Our ref: DOC21/16583

Senders ref: SSD 8924 MOD 1 (City of Sydney)

Subject: The New Sydney Fish Market – Concept and Stage 1 SSD 8924

EES have reviewed the Modification Report and relevant documents and make the following comments.

AR-S1-A21 L00-01 F

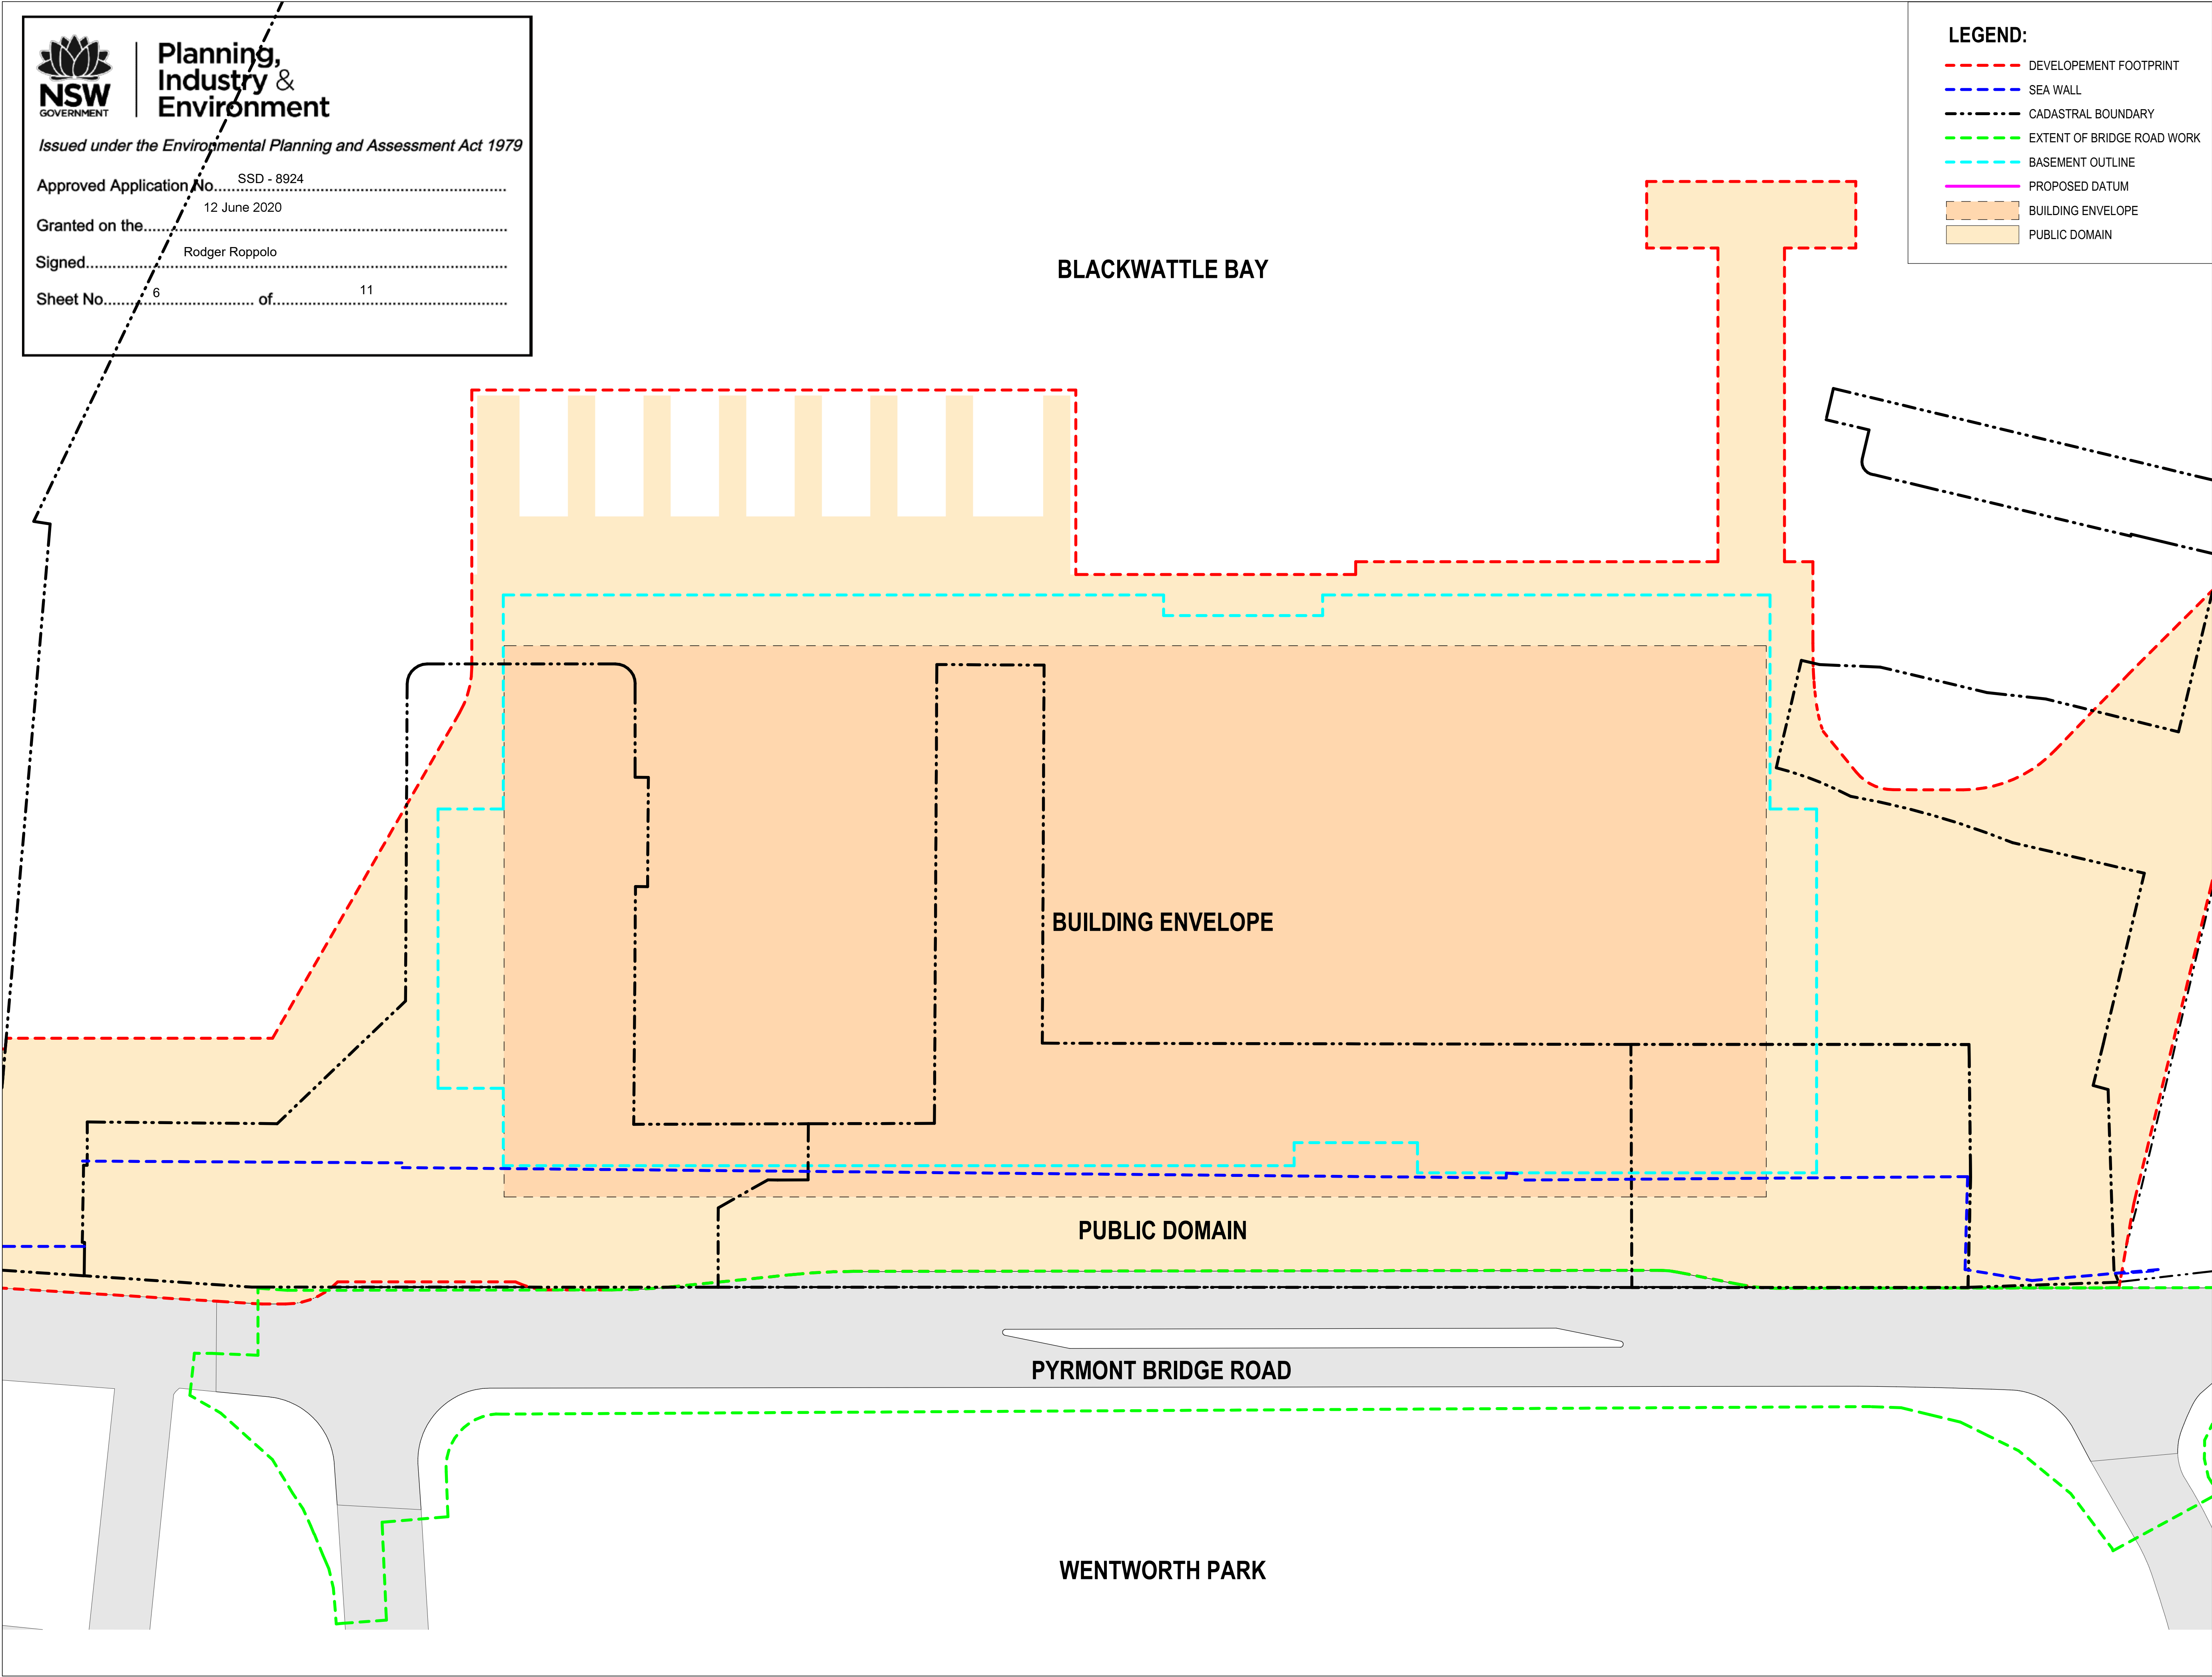
However, EES notes that the Demolition Plan AR-S1-A21 L00-01 for SSD 8924 (Issue G) still indicates one wharf (occupied by an outdoor dining area of the existing fish market) and two jetties on the eastern side of Blackwattle Bay, within Lot 1 in DP 835794, as “Main works demolition of existing fish market wharf to occur after relocation to new facilities”.

This was previously questioned in a meeting with Infrastructure NSW on 3 August 2020 in which Jennifer Chang confirmed that demolition of these wharves and jetties had been given consent “as a later stage”. However, only one of these structures the “existing SFM wharf and outdoor dining area which is located along the foreshore on the western side of the main fish market building” is included in the EISs for SSD 8924 and SSD 8924, being shown on Figure 2 as being within the development footprint and referred to in section 2.4.1 as one of the “buildings, structures, wharves and jetties [that] are to be demolished as part of this application”. The two jetties are not mentioned in either EIS.

EES therefore, firstly, seeks clarification from the Planning and Assessment Group as to whether the demolition of any of these structures is covered by the approved developments 8924 or 8925 or whether their demolition is to be subject to separate development approval.

Secondly, pertinent to this is that *none* of these structures has yet been surveyed by inspections or ultrasonic detectors for the habitat or presence of threatened microbats, even though these structures could afford habitat for threatened microbat species – see Figure 10 of the biodiversity development assessment report (BDAR) and also confirmed by the ecological consultants. This is contrary to the requirements of the BC Act and to recommendations by EES in correspondence of 14 November 2019 (our ref. DOC19/891083).
